July 16, 2021

**Project Name:** Super Star Car Wash - Falcon, CO  
**Project No.:** 020441-01-001 // PPR-21-008

This letter is in response to the letters dated March 11, 2021 – April 14, 2021.

SEAL		
NOT FOR CONSTRUCTION		
DESIGN	DRAWN	CHKD
SWK	SWK	TOP
SCALE	H: 1" = 20' V: 1" = XXX'	
JOB No.	020441-01-001	
DATE :	02/09/2021	
SHEET	C2.0

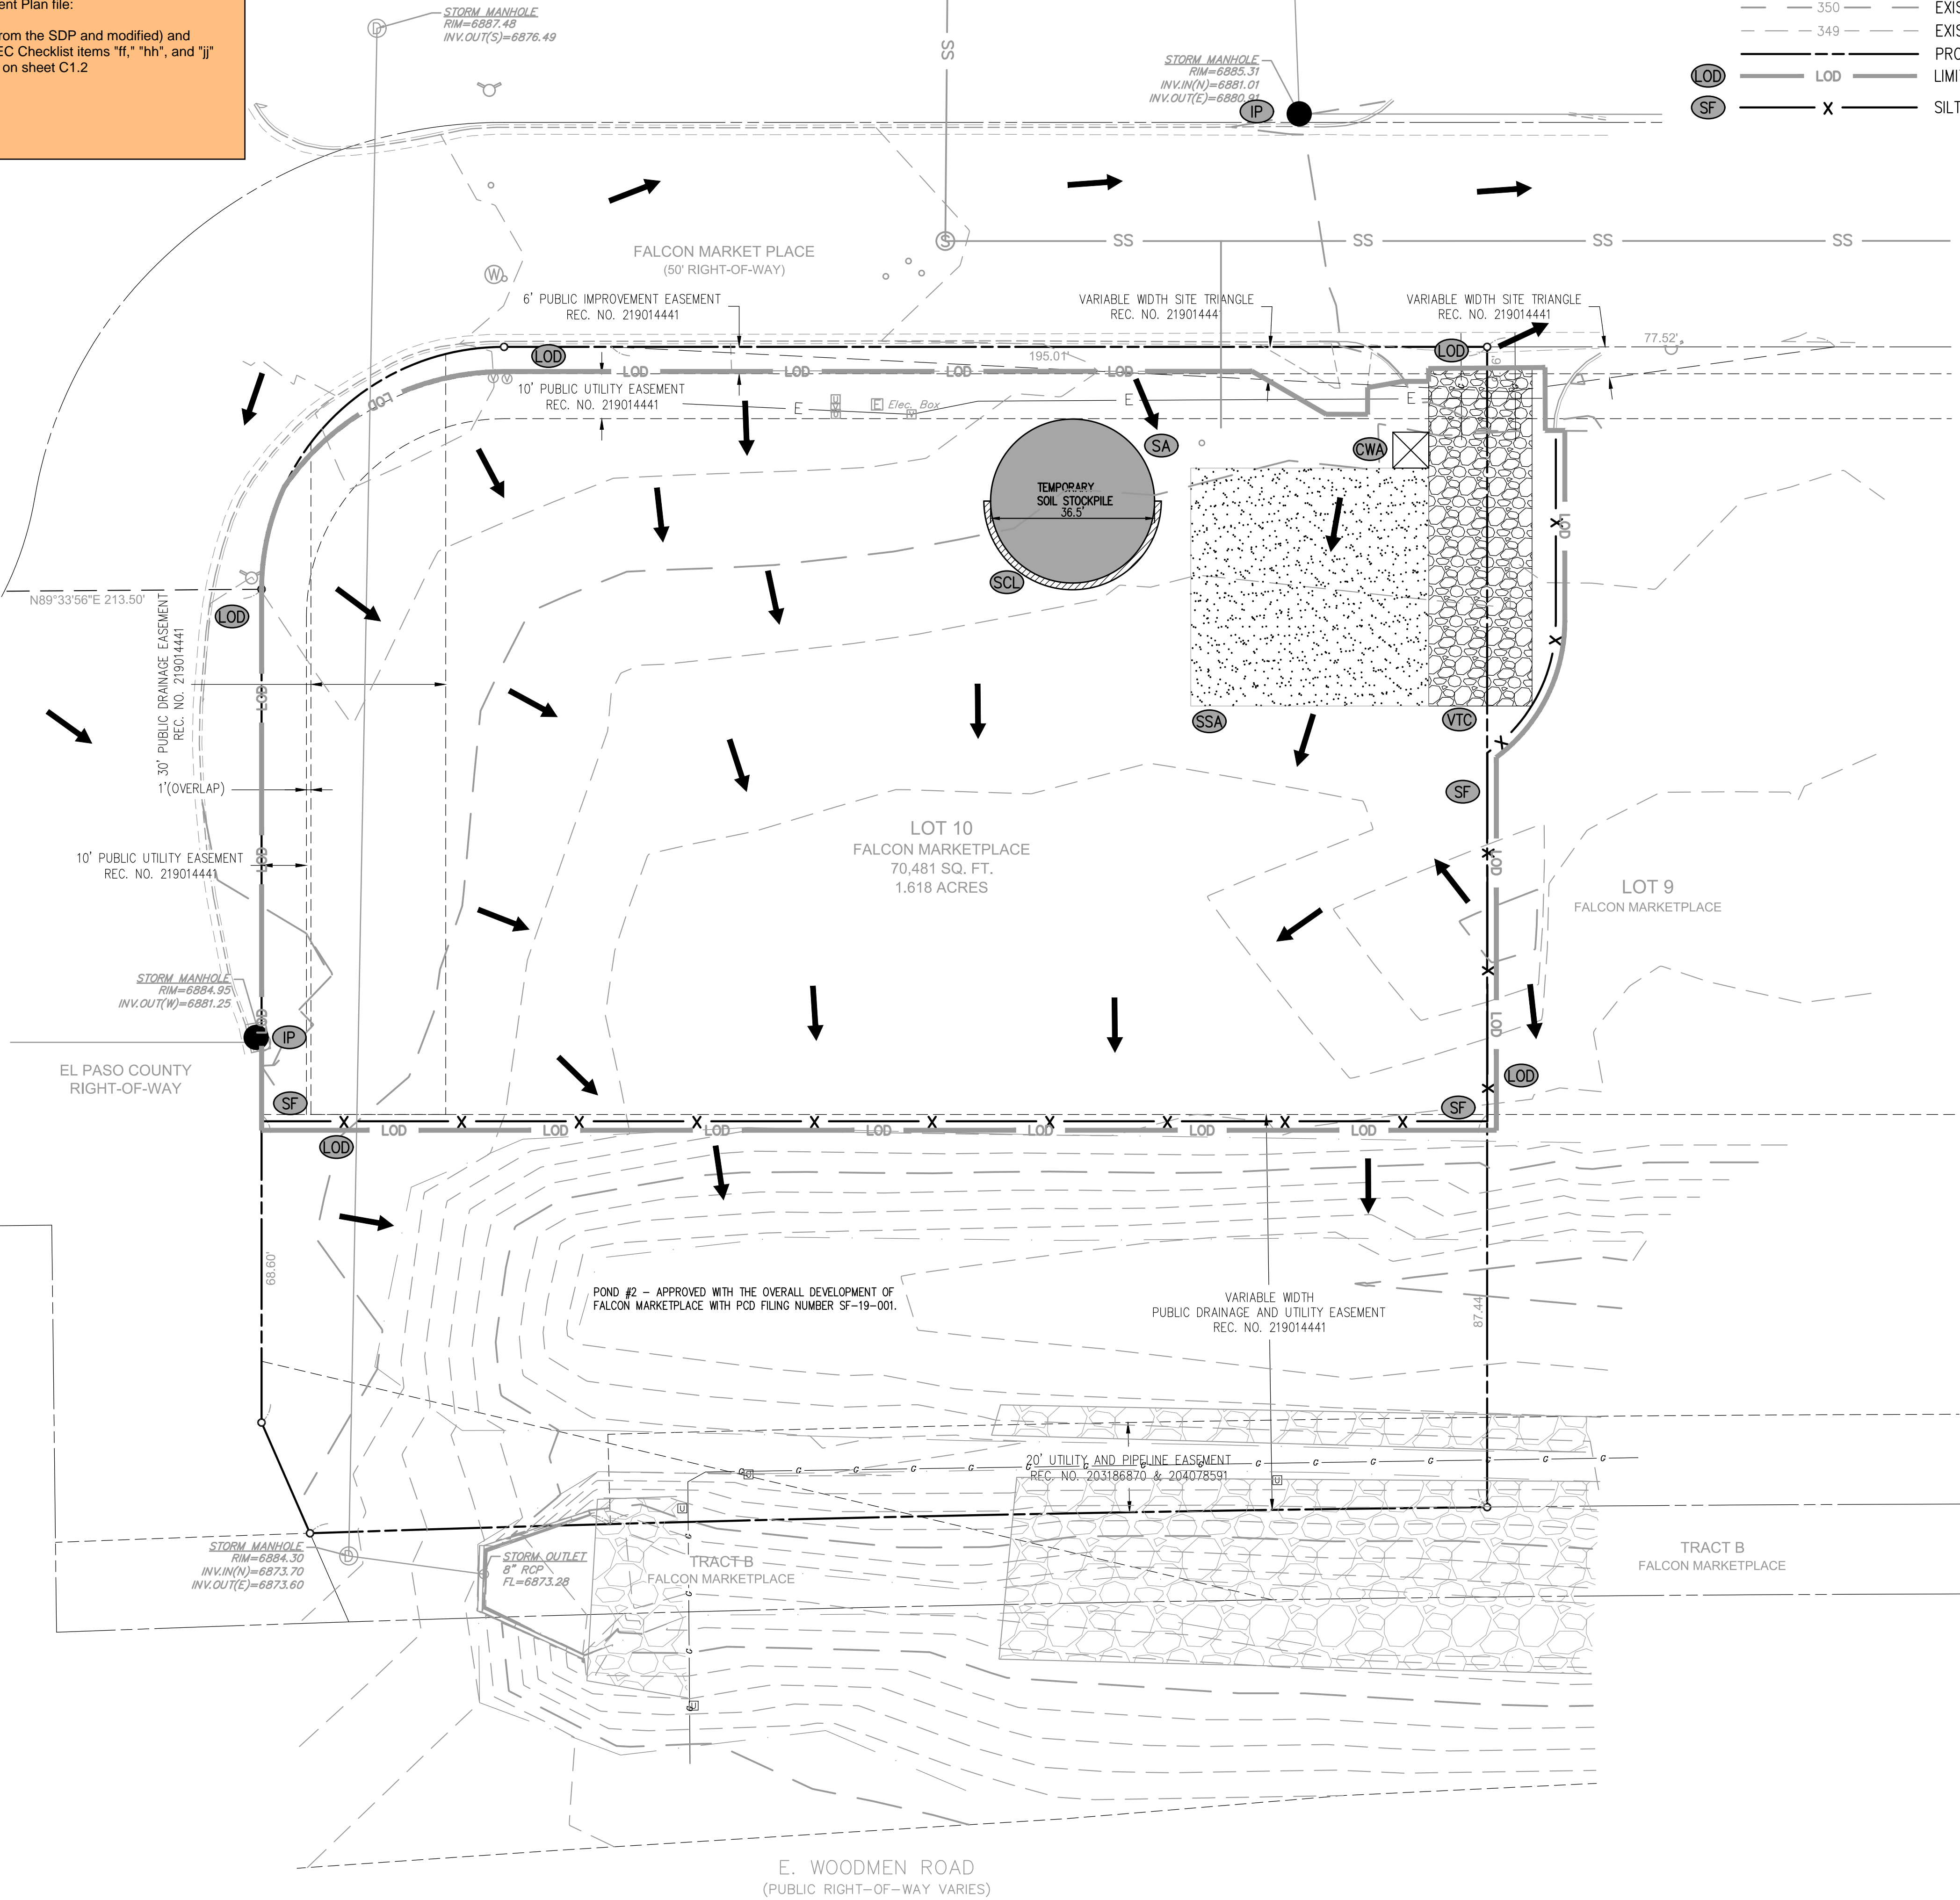
6. C2.0 - Drainage Map in Drainage Letter shows a 5' inlet at this location. If there is one there, will need to show IP.

7. C2.0 - Label as: Pond #2 - approved with the overall development of Falcon Marketplace with PCD filing number SF-19-001.

- Checklist Item B - label the surrounding subdivision names, lot #'s, and/or parcel #'s
- label adjacent roads.
- Checklist Item H and M. If "limits of disturbance" and "construction boundary" are the same, change to "construction boundary/limits of disturbance" or otherwise show as separate line types for each on the legend and figure.
- Item I - include a note on here (or on Sheet 2 -General Erosion Control Notes) about condition of existing vegetation.
- show offsite drainage flow arrows as well
- Item P - identify areas of cut/fill. A note descriptive note is acceptable. For examples: the site is mostly cut or fill, or cut/fill in northwest corner, or site was previously graded with the rest of the overall development of Falcon Marketplace.

**Response: Inlet protection has been added to all inlets surrounding site.**

**Response: Label has been added.**

**Response: Surrounding subdivision names, lots #'s and/or parcel #'s have been added. Adjacent roads have been labeled. Boundary has been changed to be labeled as LOD only.**

**Note has been added. Offsite drainage flow arrows have been added. Note has been added for cut fill areas.**

SHEET C2.1

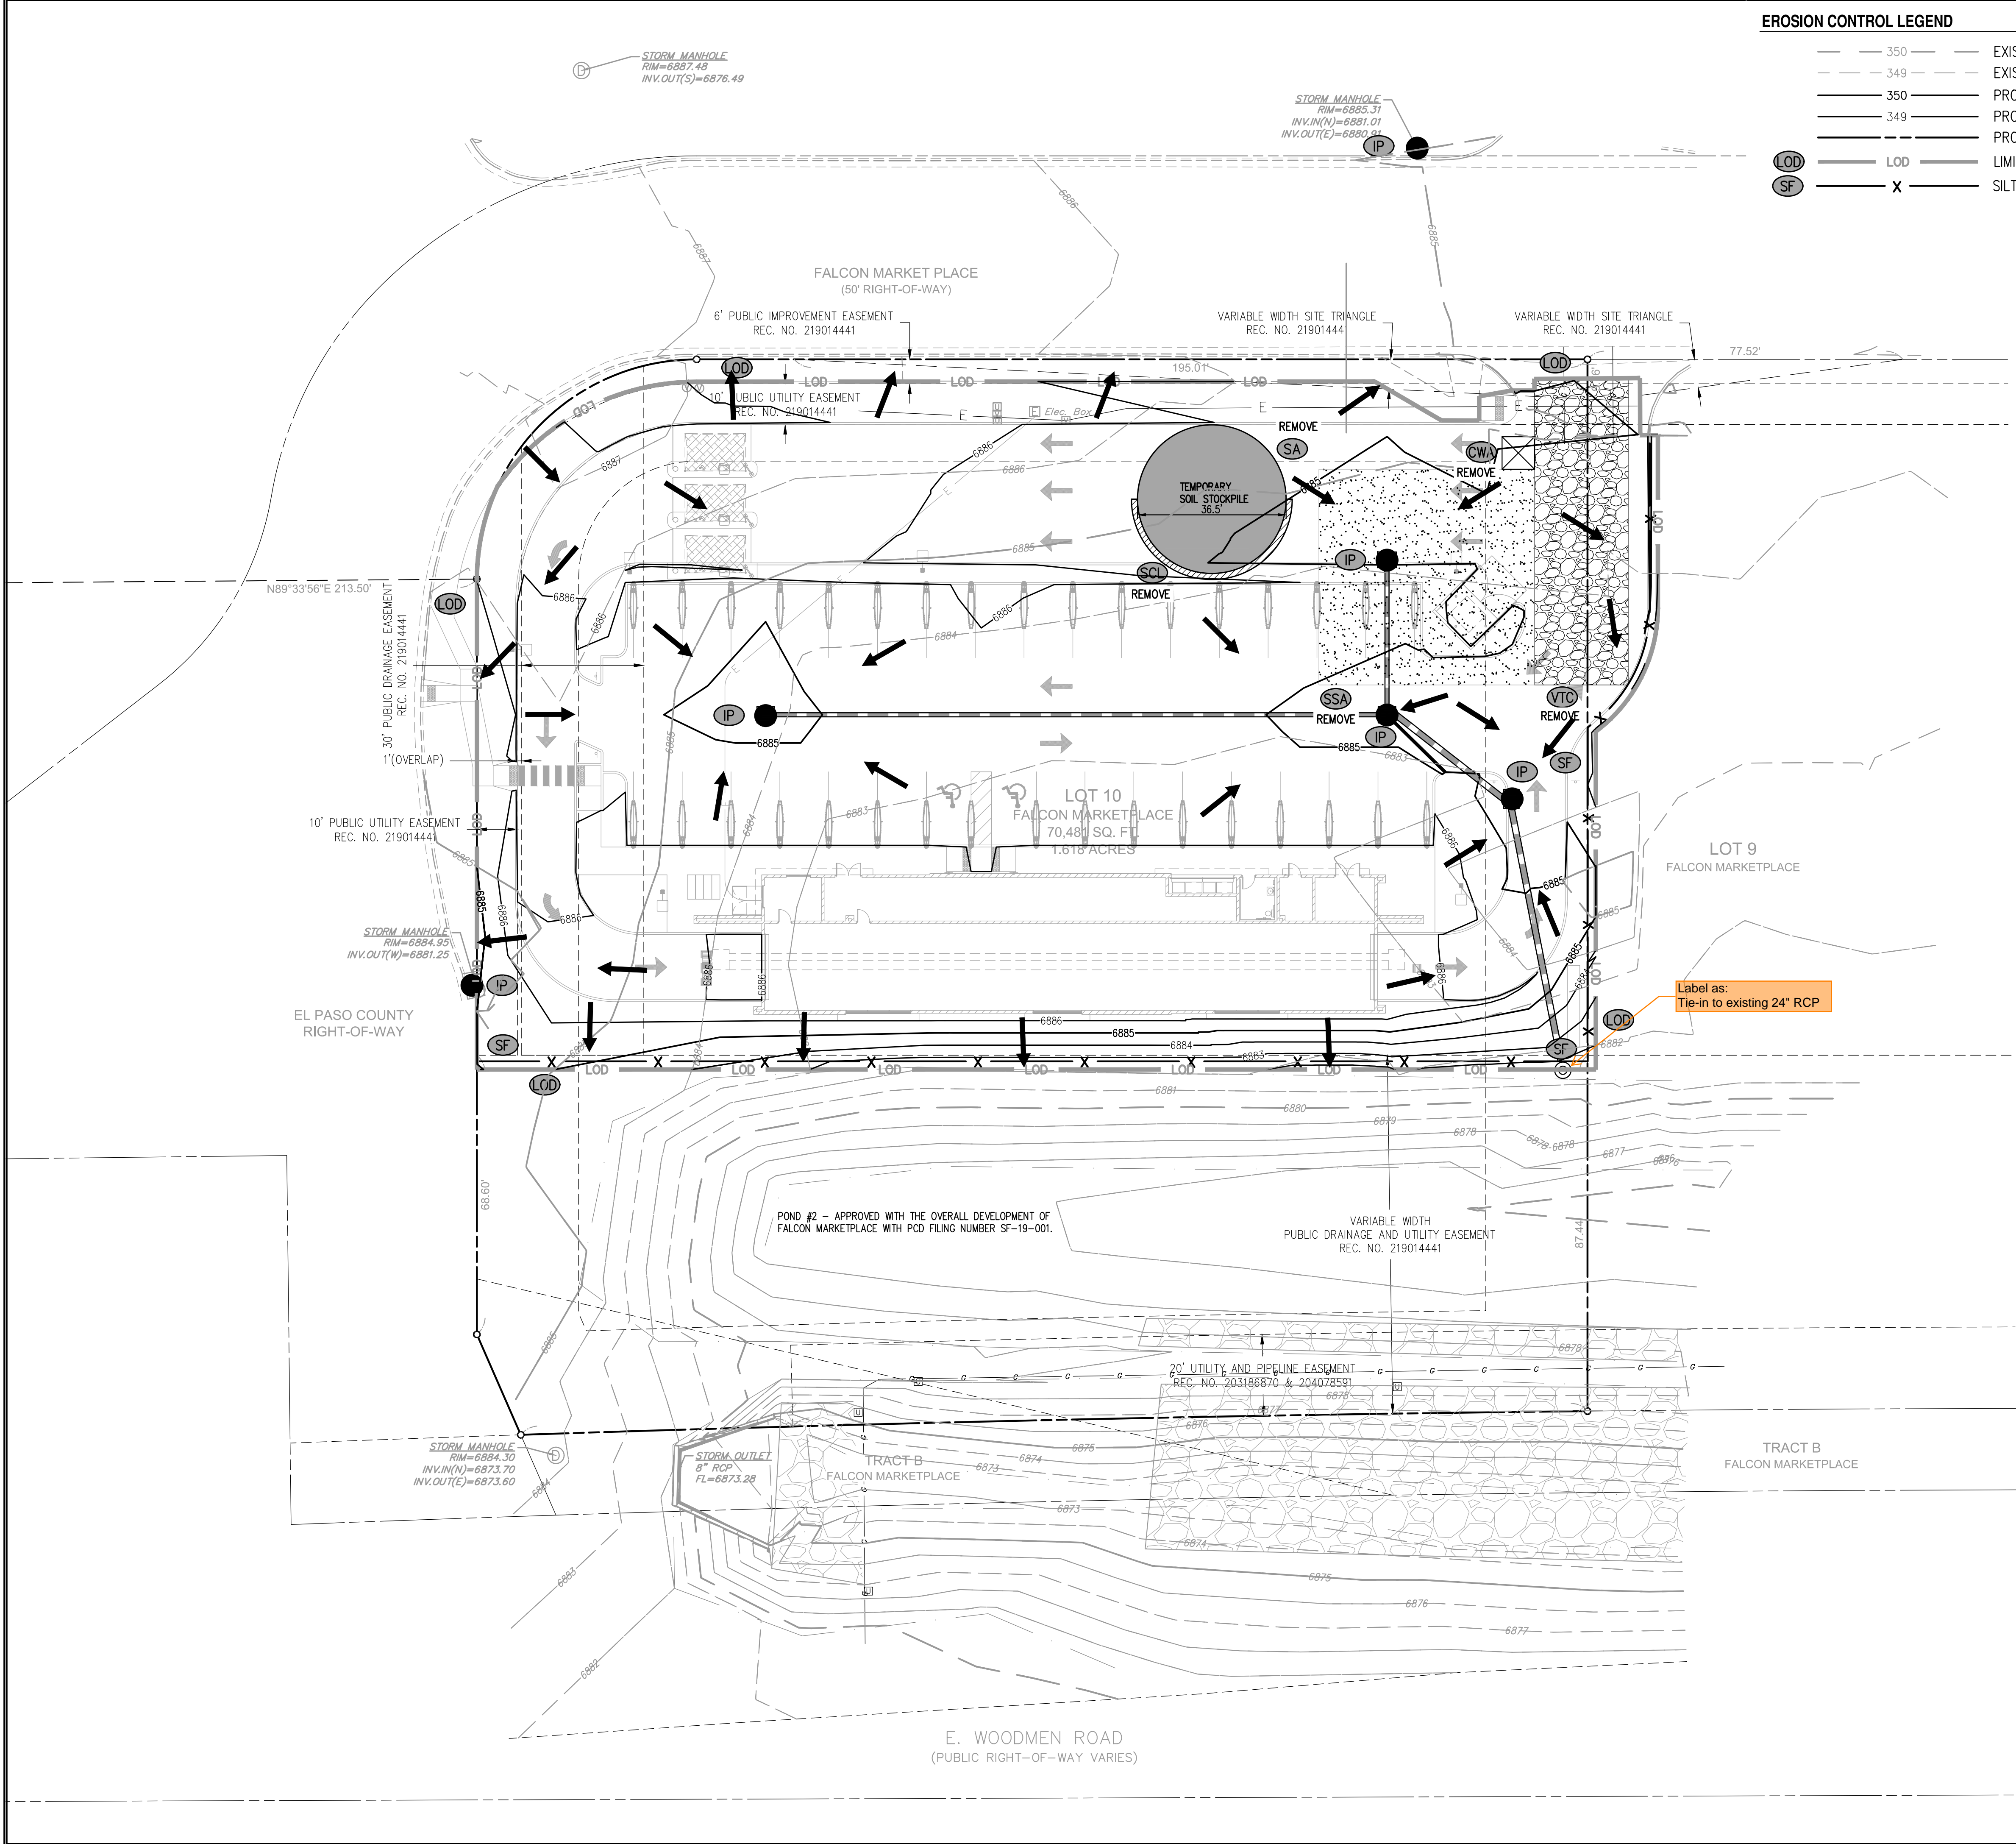
9. C2.1 - 38'-0"

10. C2.1 - Show site stormwater inlets and piping that is shown on Drainage Map on Drainage Letter. There inlets will need IP during construction and until final stabilization is achieved.

**Response: Call out added.**

**Response: Inlets and piping with inlet protection has been added to Sheet C2.1.**
